From: [Shaw, Andrew](#)
To: [Thanet Extension](#)
Subject: Thanet Extension Offshore Wind Farm DCO EN010084, notification of Hearing attendance, The National Trust 20012611
Date: 15 January 2019 16:45:03
Attachments: [20190107_TEOWrittenrepsNationalTrust10summary_v3.docx](#)
[20190115_TEOwExAQ1responseNationalTrust_v2.docx](#)
[20190115_TEOWrittenrepsNationalTrust_v4.docx](#)

Thanet Extension Offshore Wind Farm
Development Consent Order EN010084

Written representations ref: 20012611
The National Trust

Special Category Land
Plan - Sheet 1 of 2

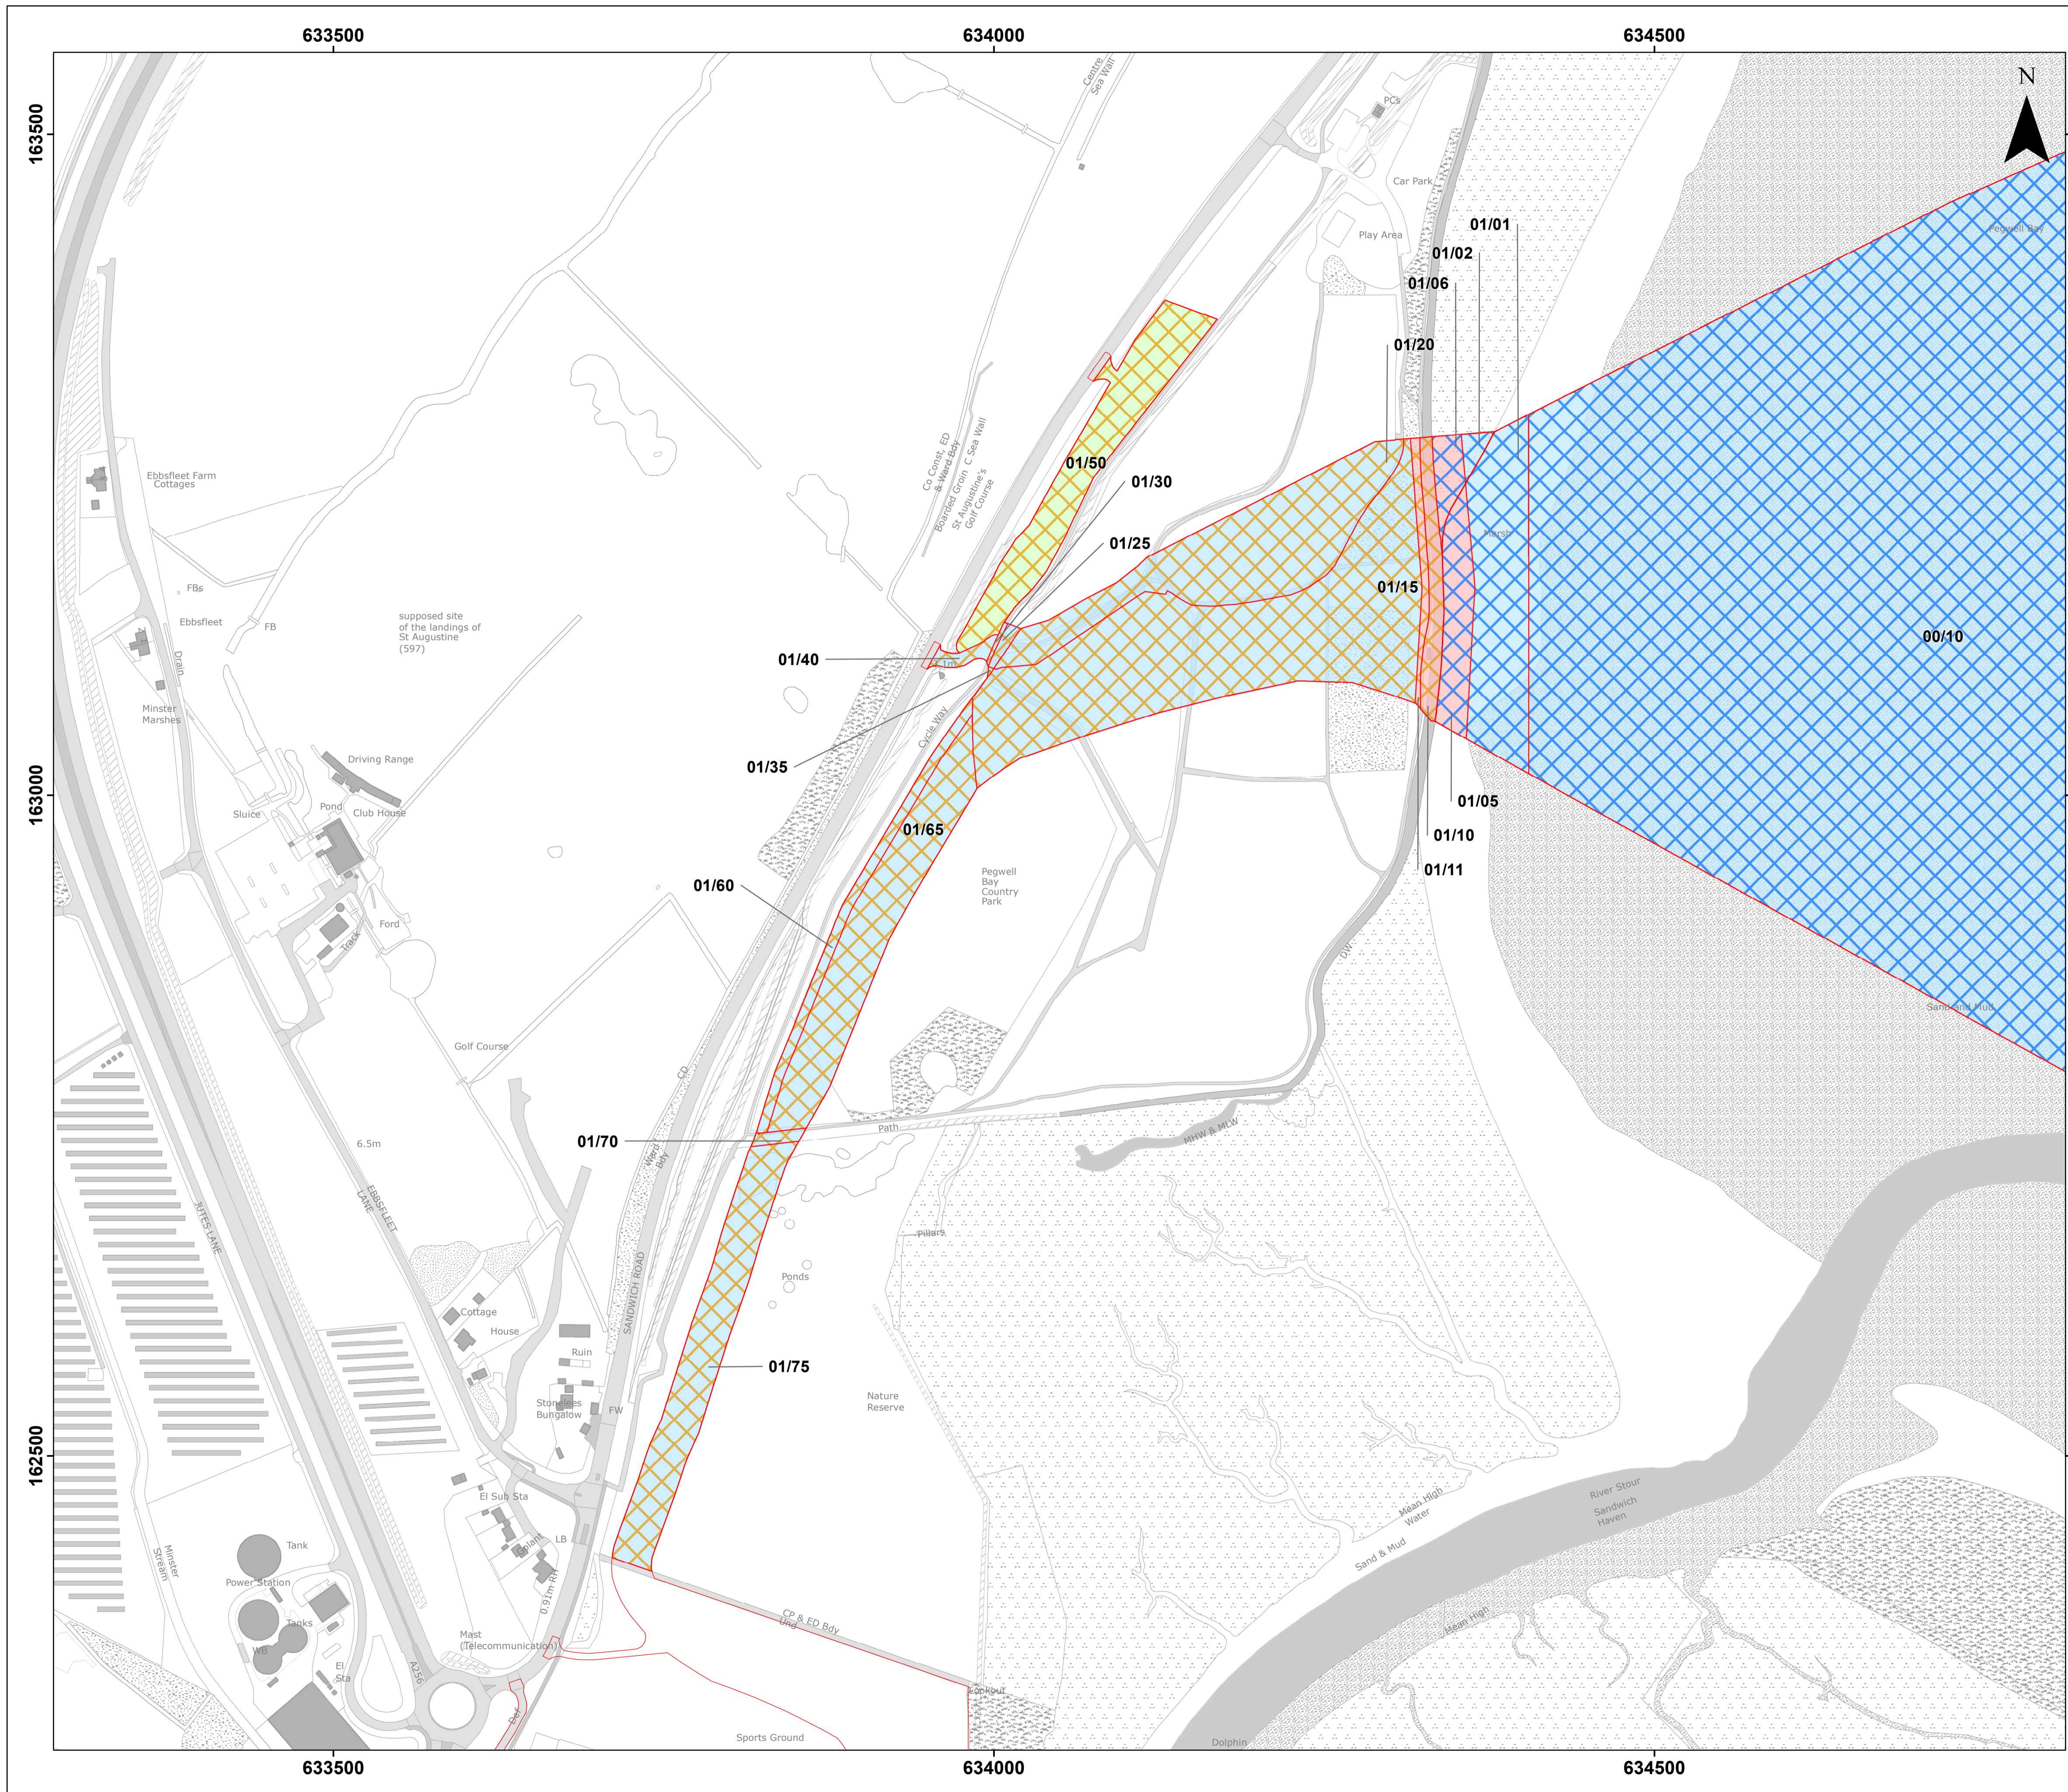
3.4 The draft DCO and supporting documents as drafted are not entirely clear about the extent of land to be acquired so could be capable of being interpreted as enabling Vattenfall to acquire inalienable land and to acquire new permanent and temporary rights over inalienable land, comprising a large area of the mudflats. The temporary possession powers are required for the construction of the works. The land affected is shown in the land plan (onshore) [document 2.3] and described in the book of reference [document 4.3]. Because the land is inalienable, it is also shown in the special category land plans [document 2.4]. The Trust is described in the book of reference as being the freehold owner of Plots 00/05, 00/10, 01/01, 01/02, 01/05 and 01/06.

4.1 The National Trust inalienable ownership includes an area of onshore land within the Proposed Onshore Development Boundary, adjacent to the rock armoured sea wall. The developers have indicated physical alterations which might affect the area, including installing a Transition Pit and extending/altering the sea wall.

4.2 The National Trust has not been provided with any detail and thus records an objection to any proposed alterations, additions or changes to this land or the sea wall or any acquisition of the Trust's land.

4.3 This relates specifically to the Works No3.B (changes to the seawall) and Works Nos 4 and 4A cable alignment. These works are within the inalienable land held by the National Trust and affected by any potential compulsory purchase or rights over land detailed under 3 above.

3.9 The Trust requires an undertaking that no compulsory acquisition of inalienable land (including the acquisition of rights over that land) will take place.

Figure 4.5 Cross Section of above ground TJB

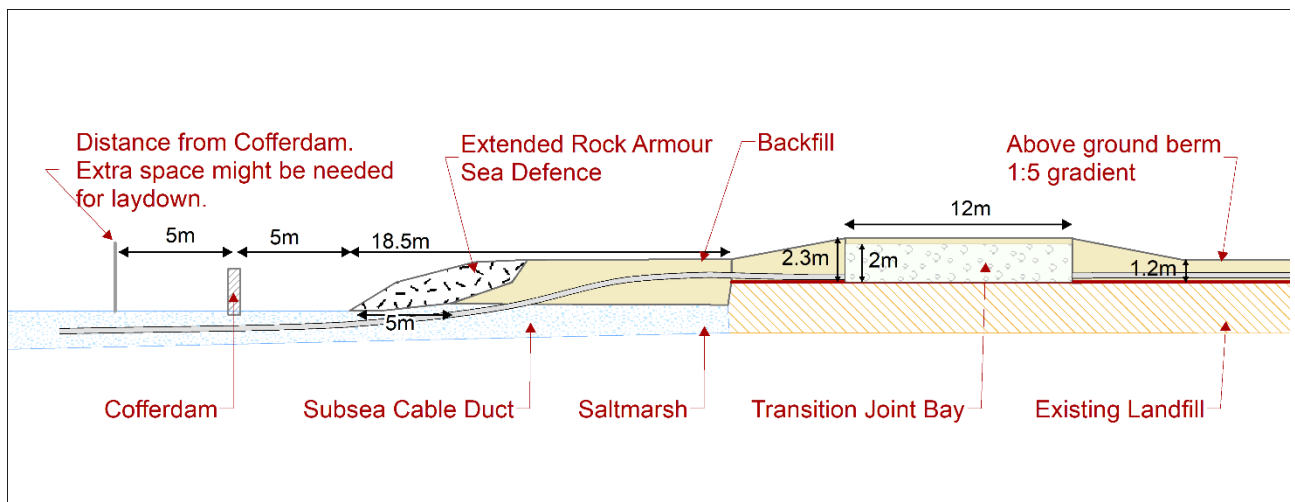
5.1 The impact of the cable route on Pegwell Bay Country Park varies with the options put forward; the above ground option 2 has the most short and long term impact on the Park, its management and users. The installation of a berm and the resulting changes to ground levels, management practices and access are not compatible with the purpose and vision of the Country Park. An over ground berm is not seen as acceptable, especially in light of the impact and lessons learnt from the previous cable project Nemo that has impacted on the Country Park.

5.2 However IF this were to happen then the need for a complete landscaping design and options to mitigate impact and create a single structure more in keeping with the rest of the park and the surrounding land, would be required.

5.3 The National Trust welcomes Vattenfall’s decision to withdraw the above ground Option 2. If the option to underground the cables across the Park are implemented this will significantly alter the impact of the project on the park, its management and users. It is the preferred option and considered to be the only acceptable way to accommodate the project across the park.
